**PR-2022-007397**

PS-2024-00149 – SKETCH PLAT

Lot 8A , McDonald Acres Subdivision, zoned R1-D, located at 3017 11th St NW containing approximately 0.574 acre(s). (H-14)

REQUEST: Subdivide Lot 8A into two lots of similar size, meeting R1-D area requirements

SHEET:  
1 of 2

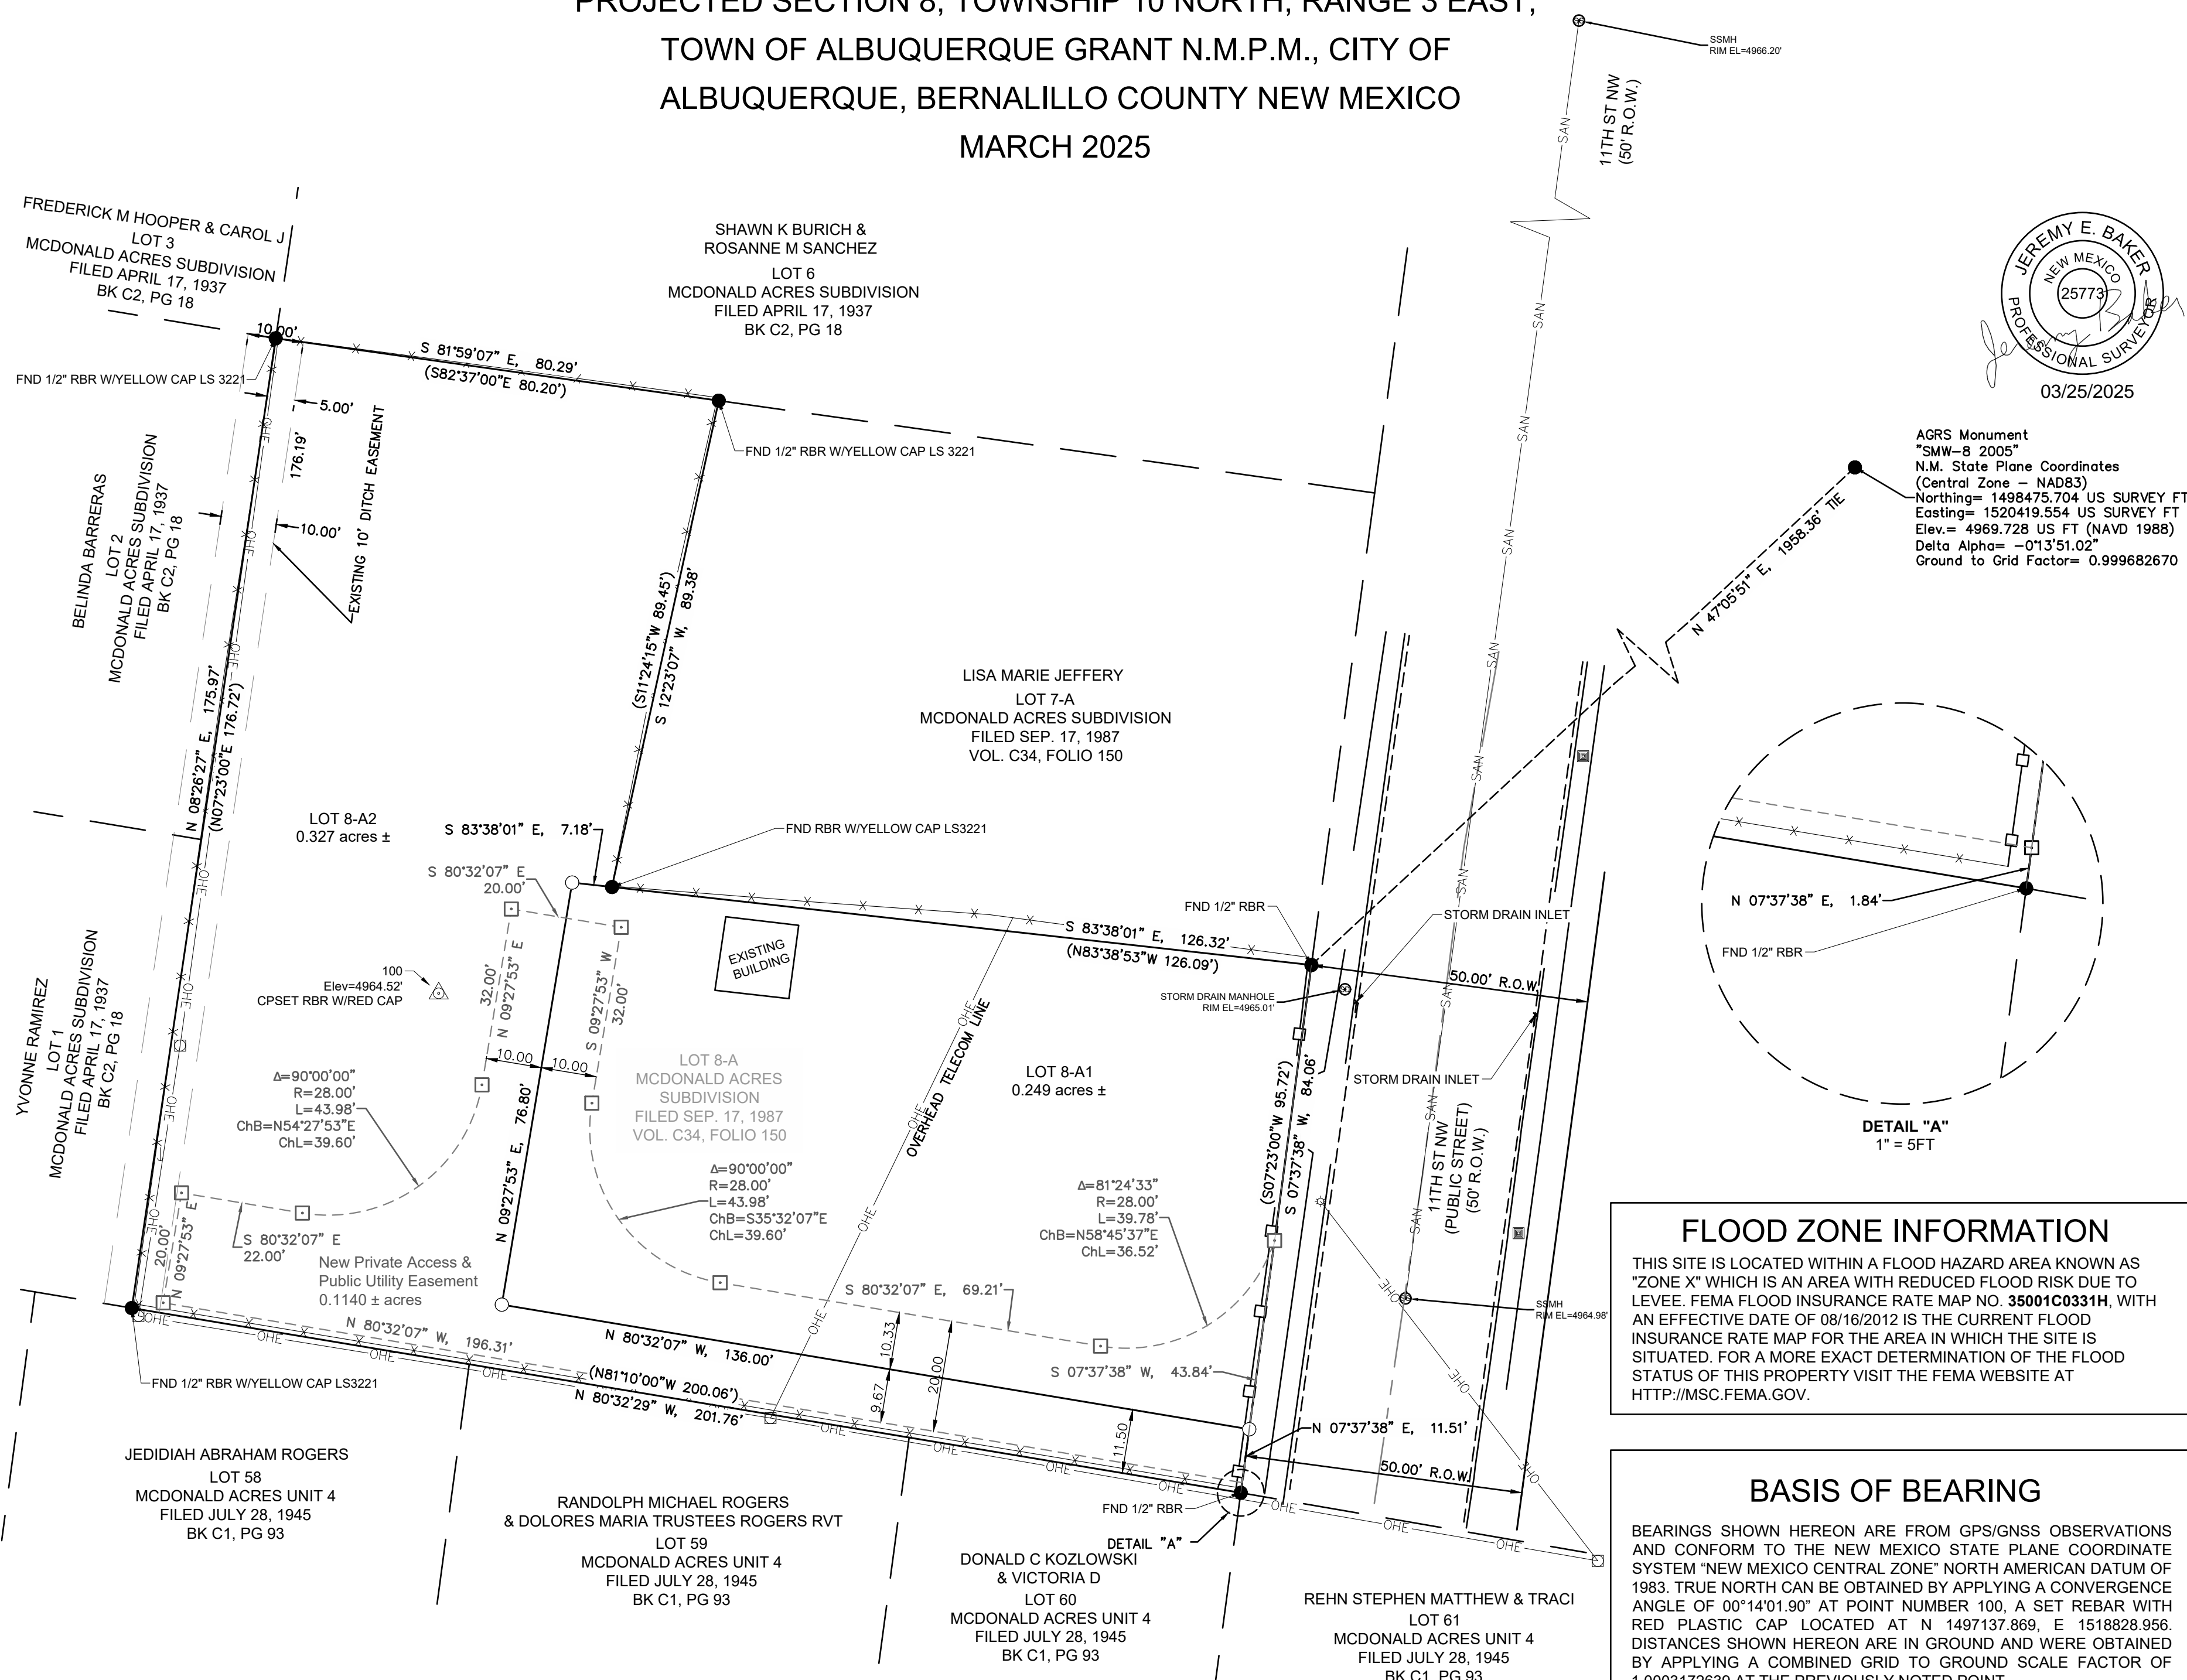
- An access easement providing access to Lot 8-A2 from 11<sup>th</sup> Street NW through Lot 8-A1 as depicted on the Sketch Plat would need to be depicted on the future required Plat as well and granted.

- Planning defers to Transportation regarding the IDO/DPM requirements for the private road/driveway as depicted on the Sketch Plat, including turn-around requirements.
